City of Albuquerque

September 14, 1995

RE: BEU-LAH 1 TOWNHOUSES (G15-D46) DRAINAGE AND GRADING PLAN FOR
BUILDING & GRADING PERMIT. ENGINEER'S STAMP DATED 8-31-95.

**A PROPOSED DRAINAGE PLAN
FOR
"BEU-LAH I TOWNHOUSES"
GRIEGOS ROAD N.W.
ALBUQUERQUE, NEW MEXICO
AUGUST, 1995
(REPLACEMENT: 00-28-05)**

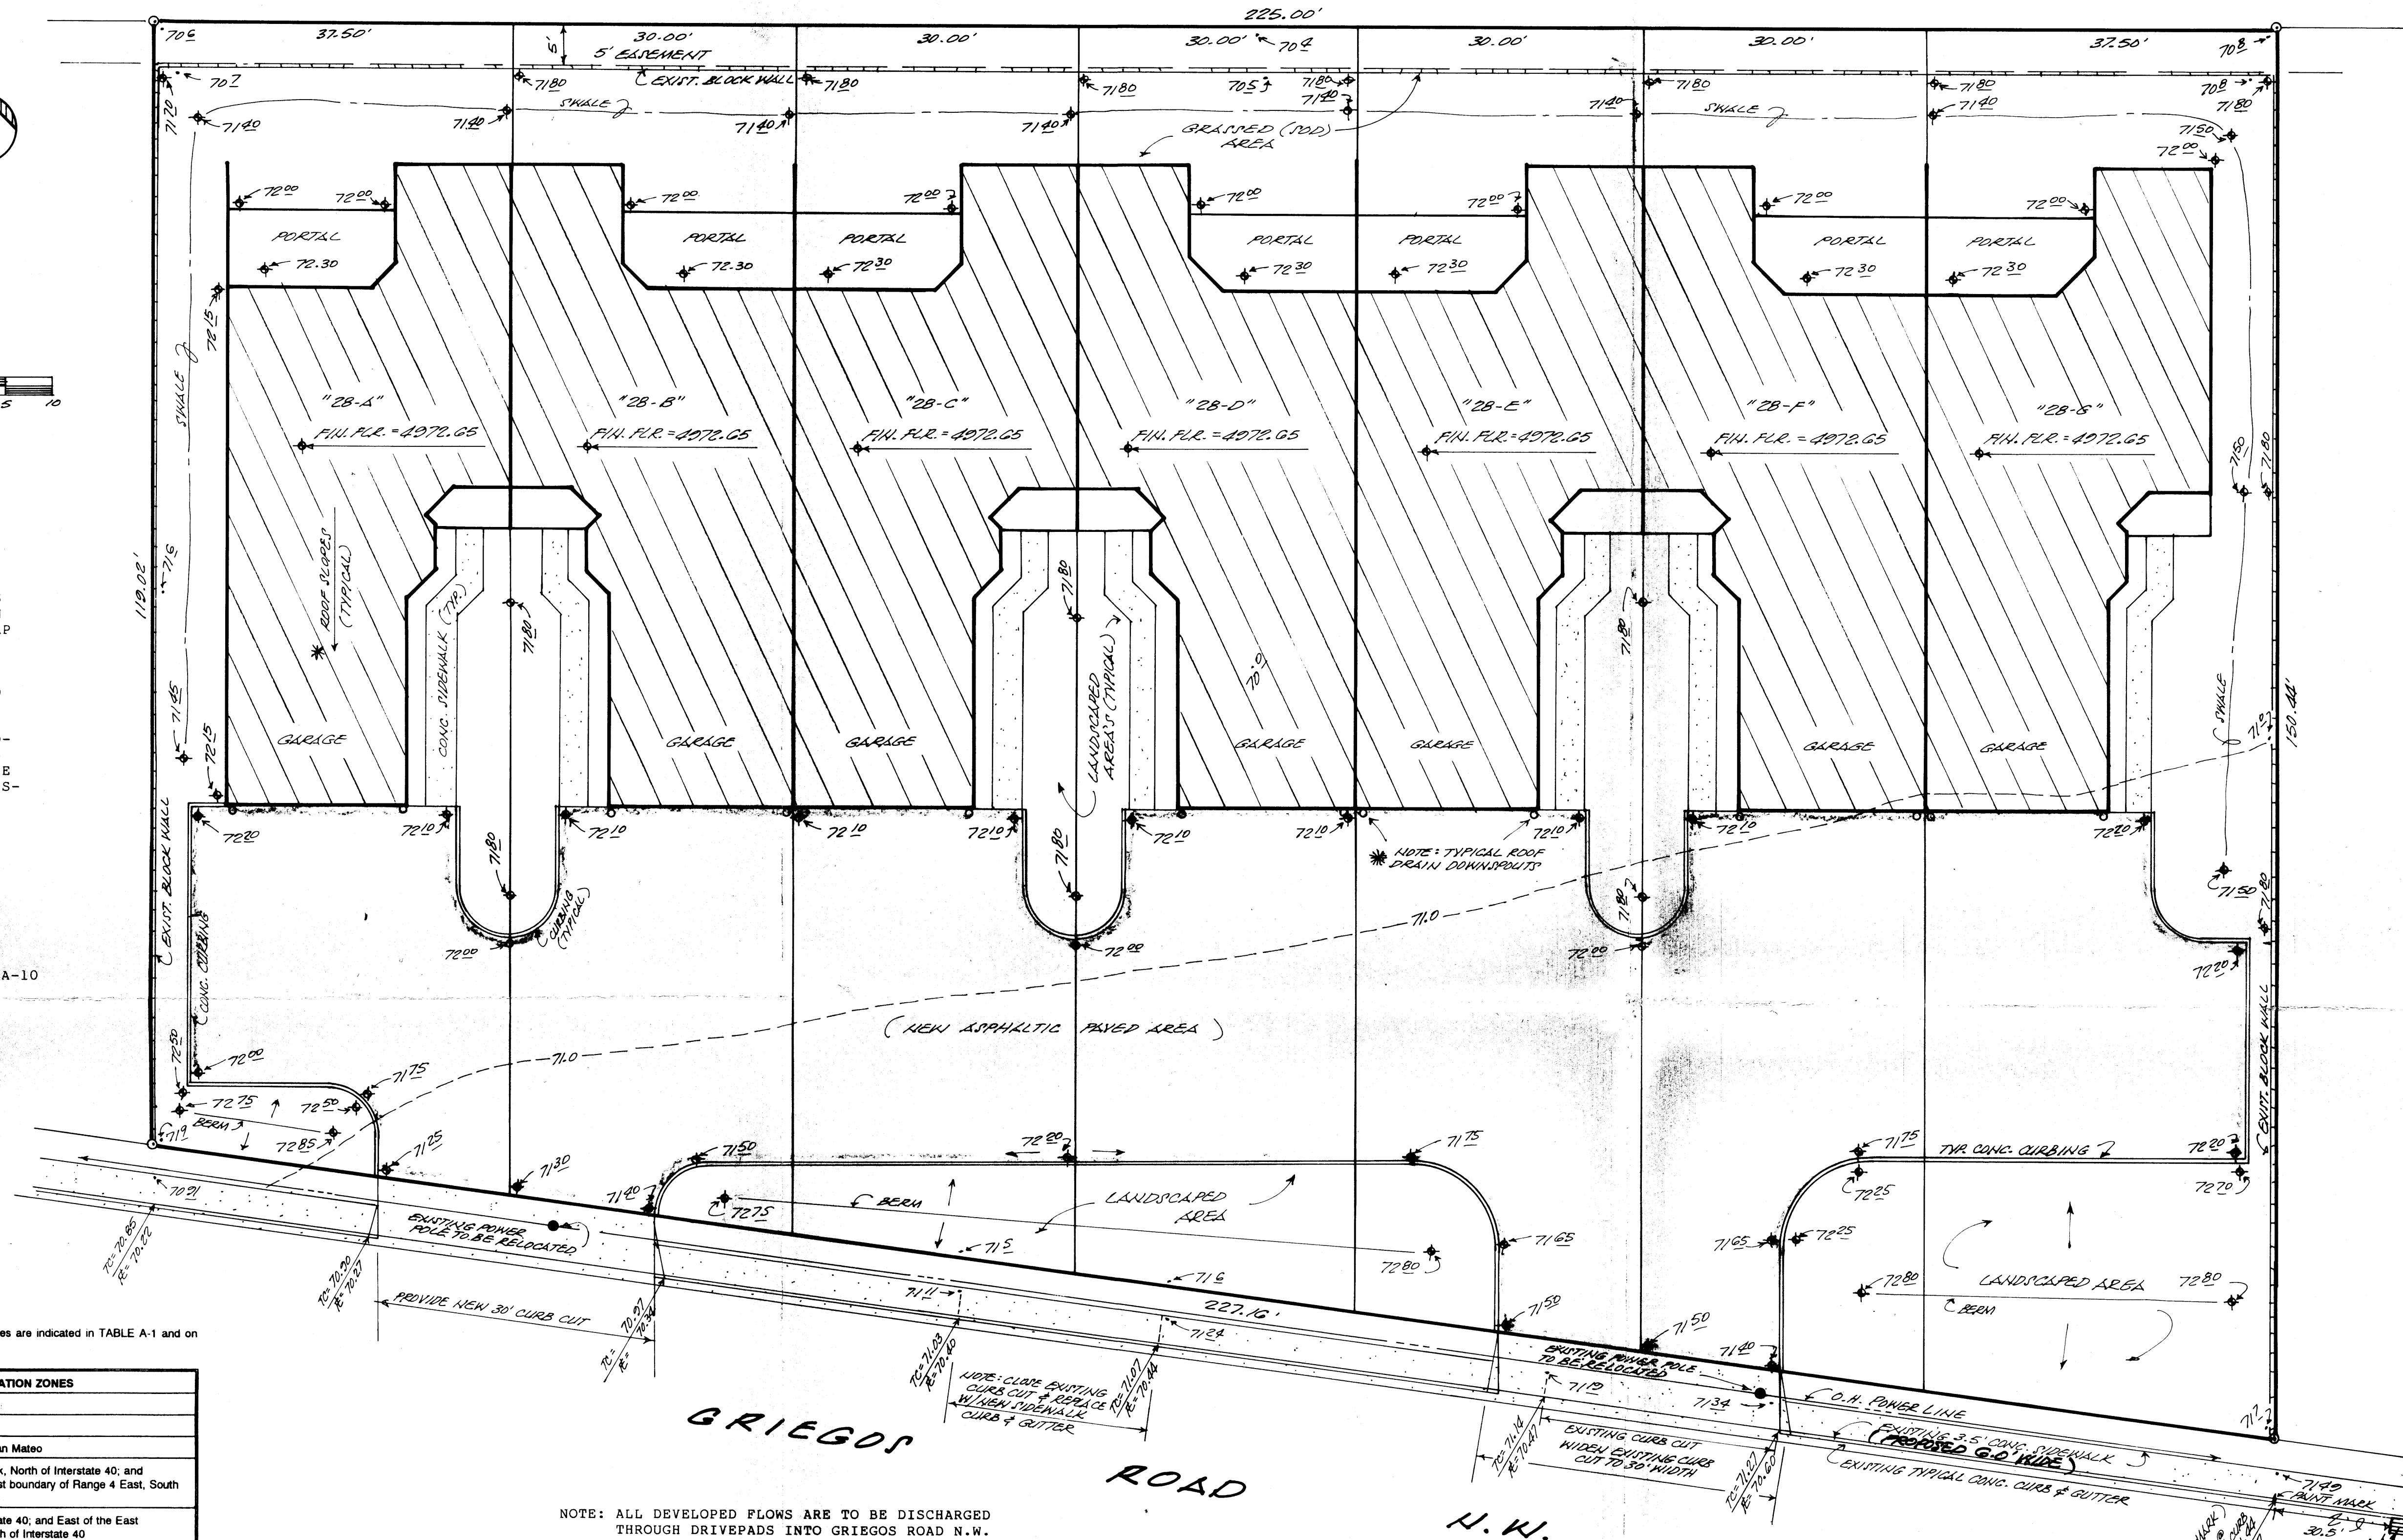
- ✓ 1. Show roof drain locations. *typical*
2. It appears that the back and side yards pond. Swales must be graded to drain runoff to the front of property. If your intent is to use cross lot drainage, you must provide a private drainage easement. Also, please provide specific information on who will maintain the easement. Do you have an approved plat for this site?
plat has blanket easement
3. You state that you have free discharge to Griegos. Please reference the source of this statement. Is there downstream capacity for your developed flows?
catch basin doesn't
- ✓ 4. Show more grades where new drives tie into the existing street. Do you have an on site temporary bench mark?
- ✓ 5. You can not sheet flow across a public sidewalk. You must convey flow to exit at drives, or use some type of sidewalk culvert to release water. If you opt for a sidewalk culvert, you will need a SO-19.

Based on the information provided on your October 3, 1995 resubmittal, the above referenced site is approved for Building Permit.

A PROPOSED DRAINAGE PLAN
FOR
"BEU-LAH I TOWNHOUSES"
GRIEGOS ROAD N.W.
ALBUQUERQUE, NEW MEXICO
AUGUST, 1995

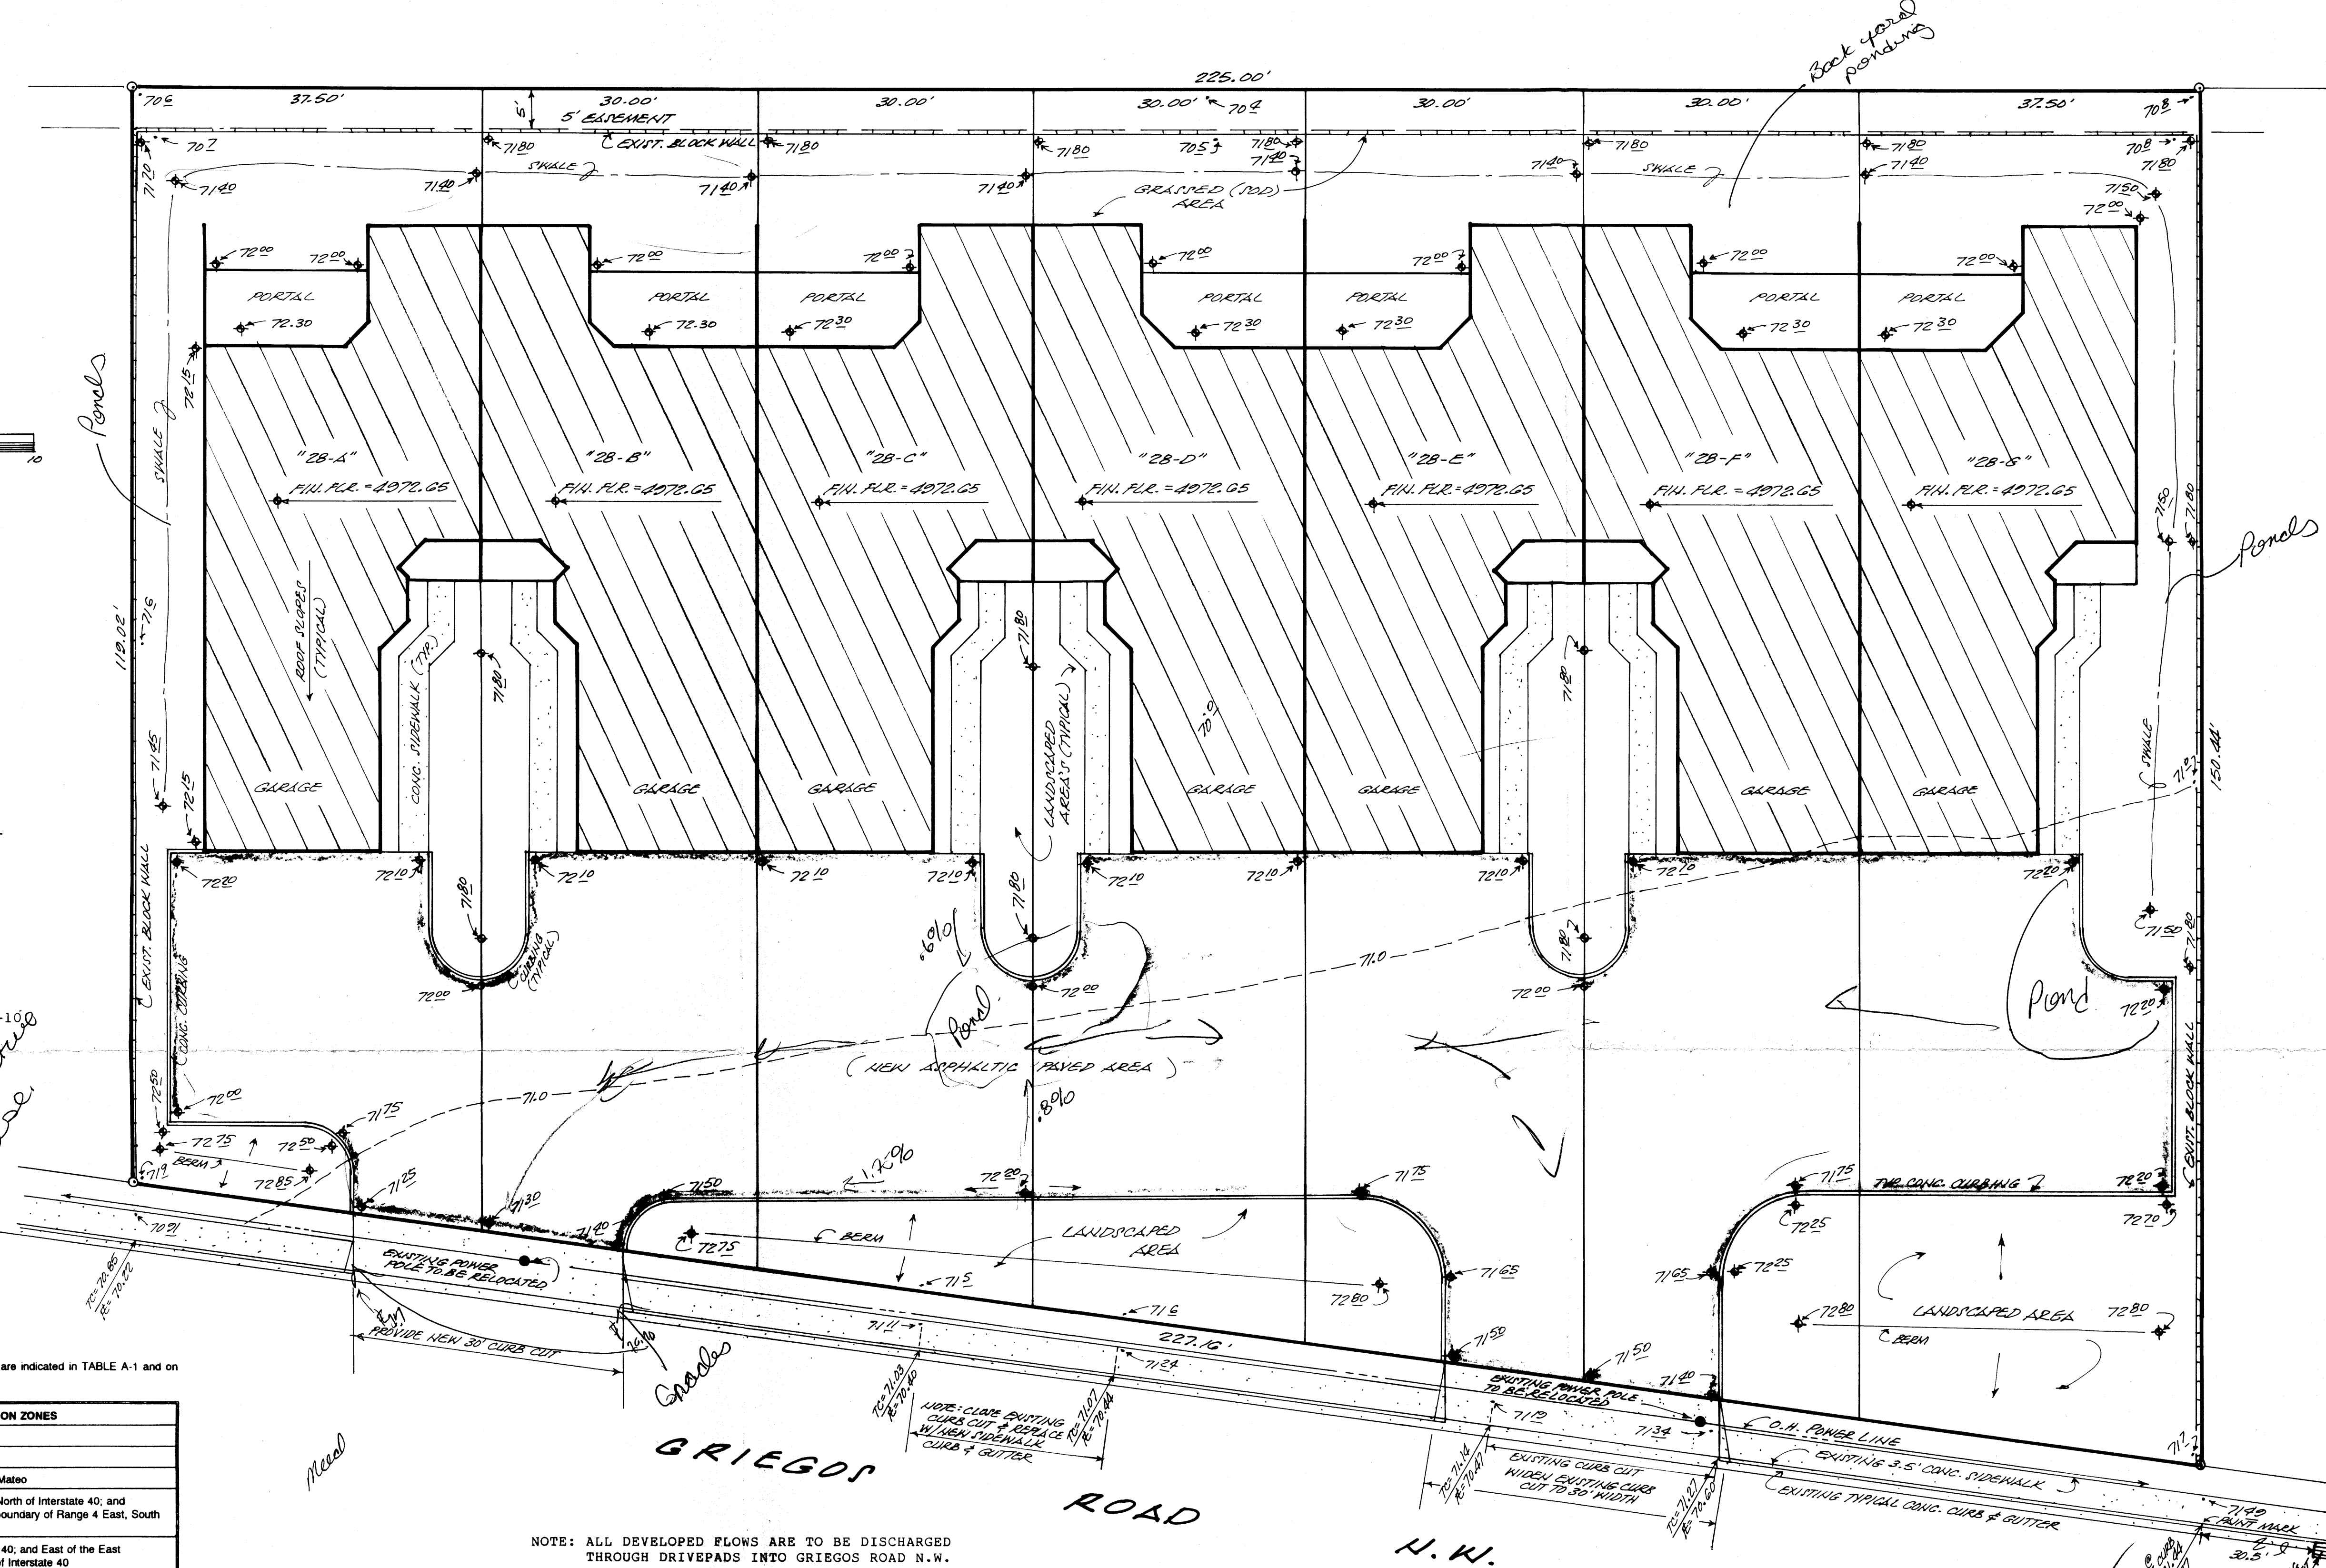
Based on the information provided on your September 1, 1995
submittal, please address the following comments:
